From: Amanda Scholes on behalf of Planning.Responses
Sent: 05 September 2017 08:35
To: Planning Scanning
Subject: FW: Planning Appl AL/83/17/PL - Demolition of "Mildmay" and erection of 2 - storey house

Please upload the objection below for Planning Application AL/83/17/PL - Demolition of "Mildmay" and erection of 2 -storey house .

From: [REDACTED]
Sent: 04 September 2017 21:44
To: Michael Eastham
Subject: Planning Appl AL/83/17/PL - Demolition of "Mildmay" and erection of 2 -storey house

PROPOSED SOUTH ELEVATION

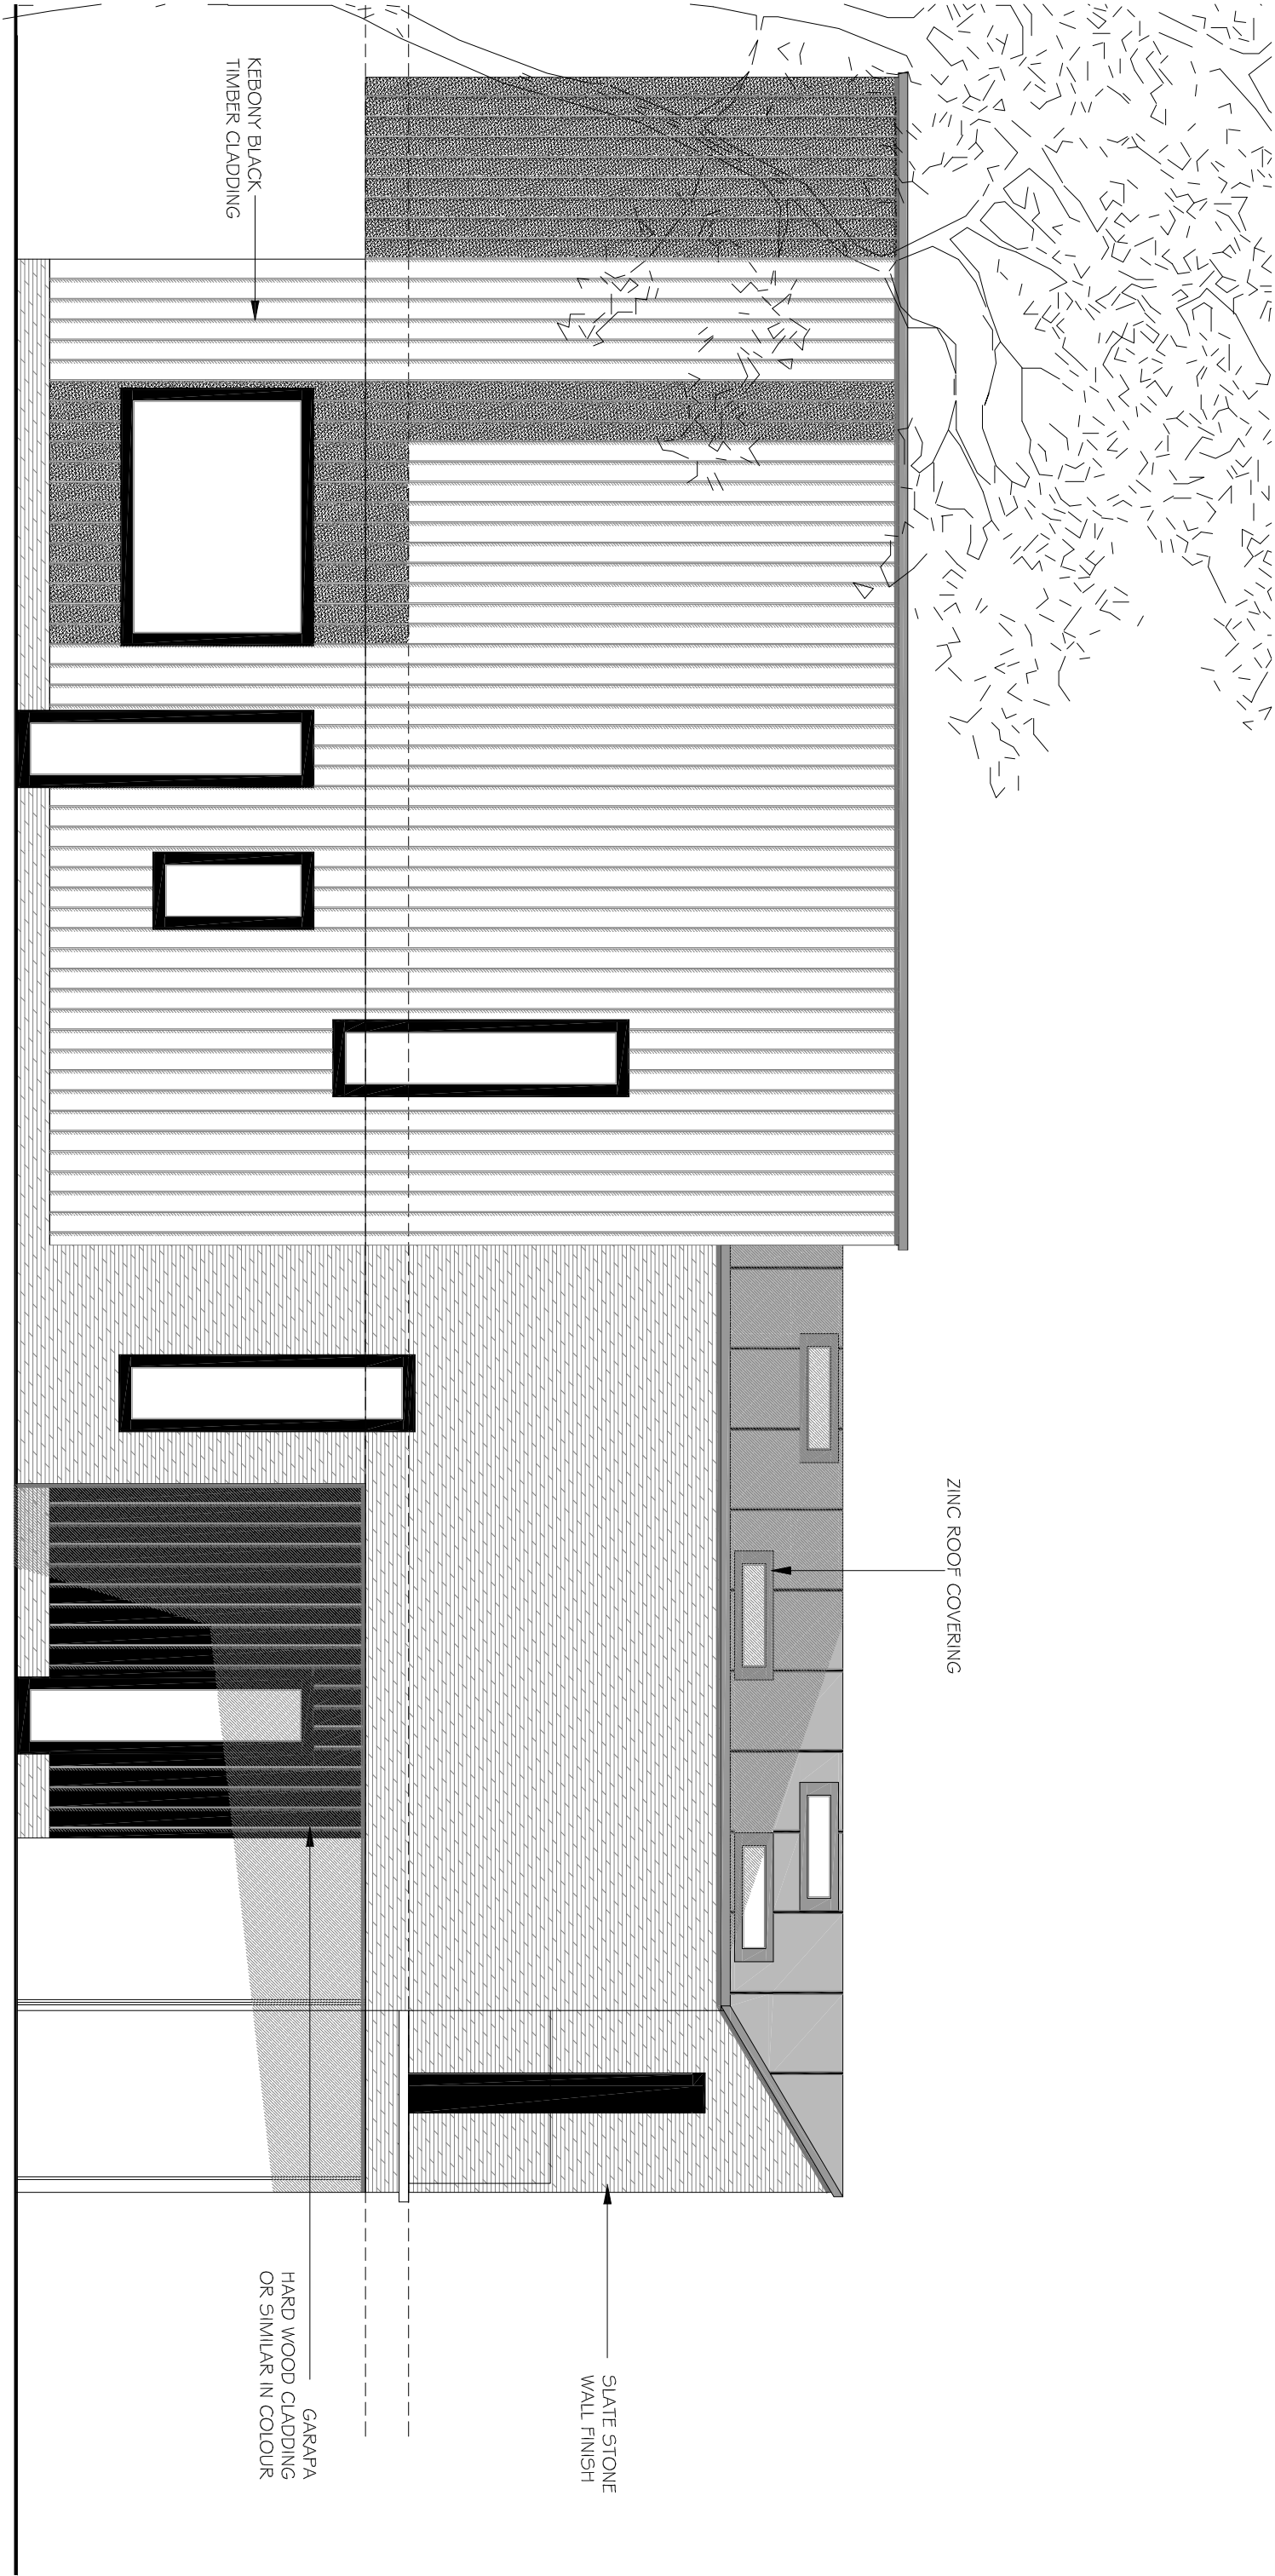
I further believe that it is wrong to allow a 2-storey dwelling to be constructed on the site of an existing single storey building which is so over-bearing to the next door single storey property called "The Nook". It is to the south of "The Nook" and therefore will cast a strong shadow most of the day onto this property and take a huge amount of the light that is presently enjoyed by "The Nook" away permanently. The extreme overhanging box-like design only exacerbates this problem. A more conventional one and a half storey chalet type design would be far less intrusive and light blocking provided it was designed with care so as not to shield too much sunlight from the south.
